Your Ref: NA
Our Ref: 002590854-01
Name: Tamsyn Rowe
Telephone: 07774 016601
Email: Tamsyn.Rowe@Innogy.com

Tues 19 December 2017

Gallopier Response to East Anglia 1North and East Anglia Two Scoping Reports

Drg No	EA2-DWF-ENV-REP-IBR-000920		
Rev	3	Datum: WGS 1984	
Date	30/08/19	Projection: Zone 31N	
Figure	28.21c

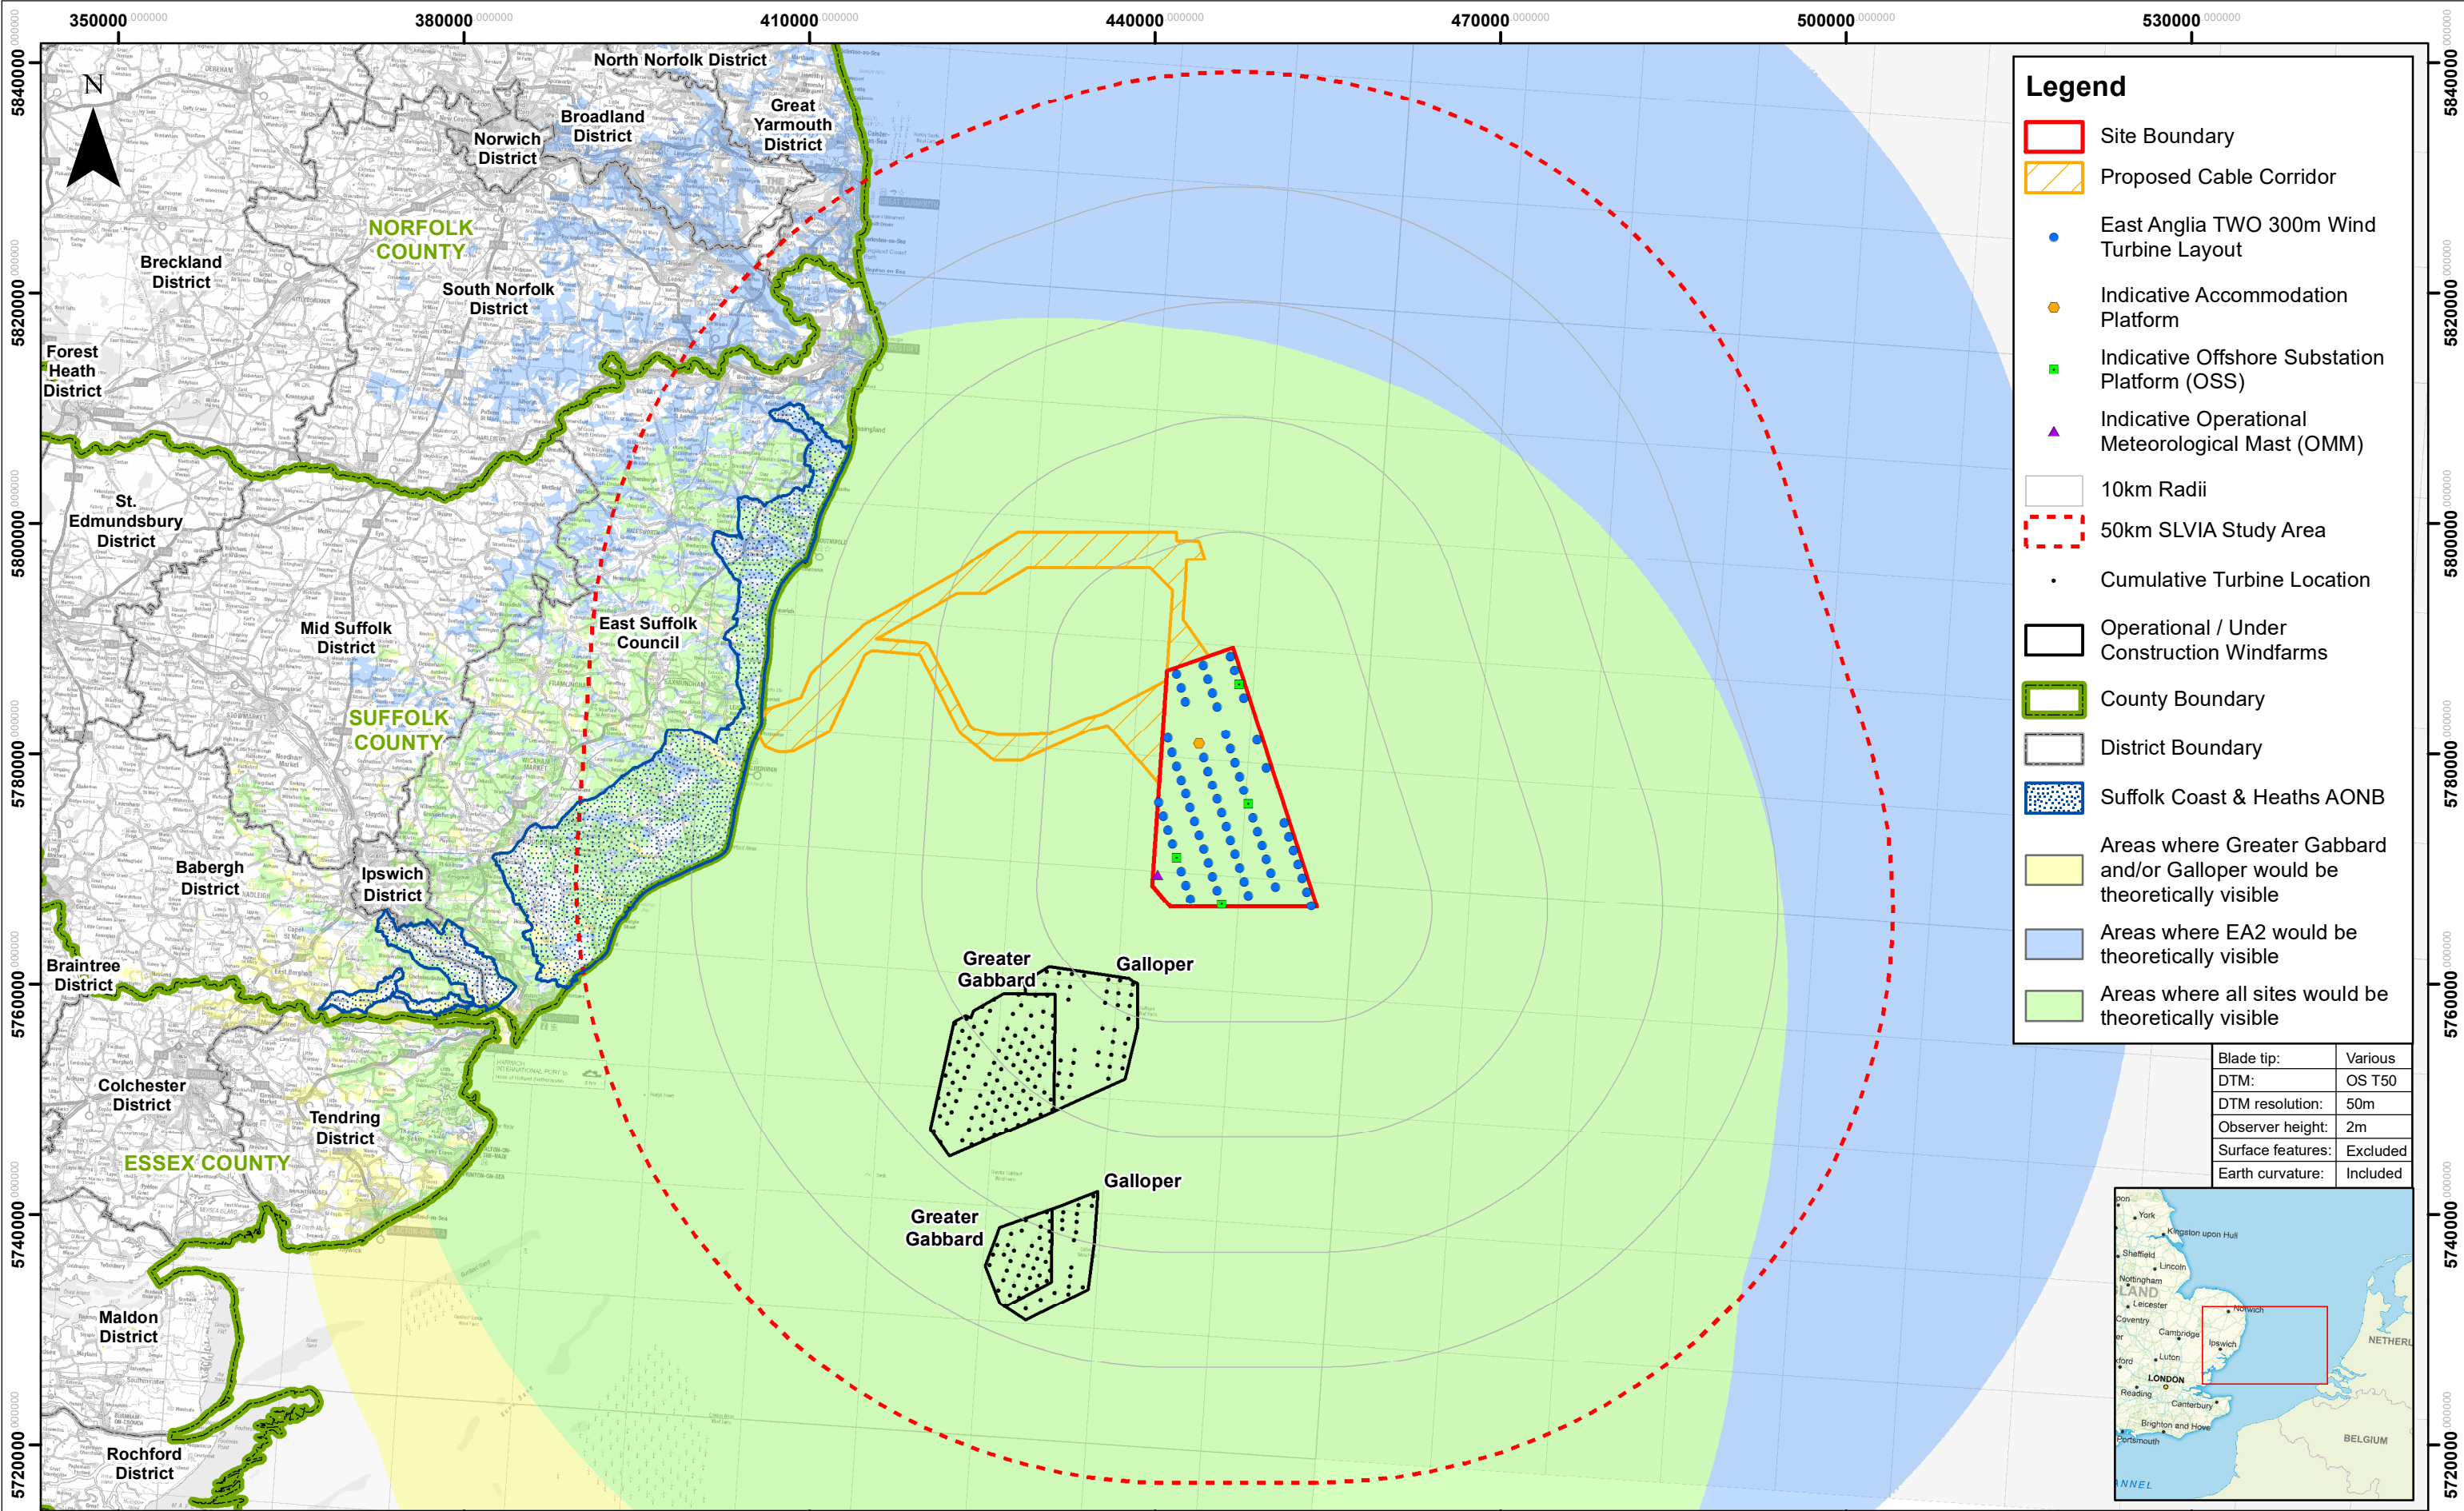
- 7) There is one AoS for a shared offshore export cable route for East Anglia One North and East Anglia Two. The figure shows the East Anglia cables will cross the Galloper cables within 10km of the shore. GWFL expects a formal cable crossing agreement between GWFL and applicable projects to be in place in advance of the DCO application being submitted. GWFL would welcome early consultation including the review of method statements in relation to this.
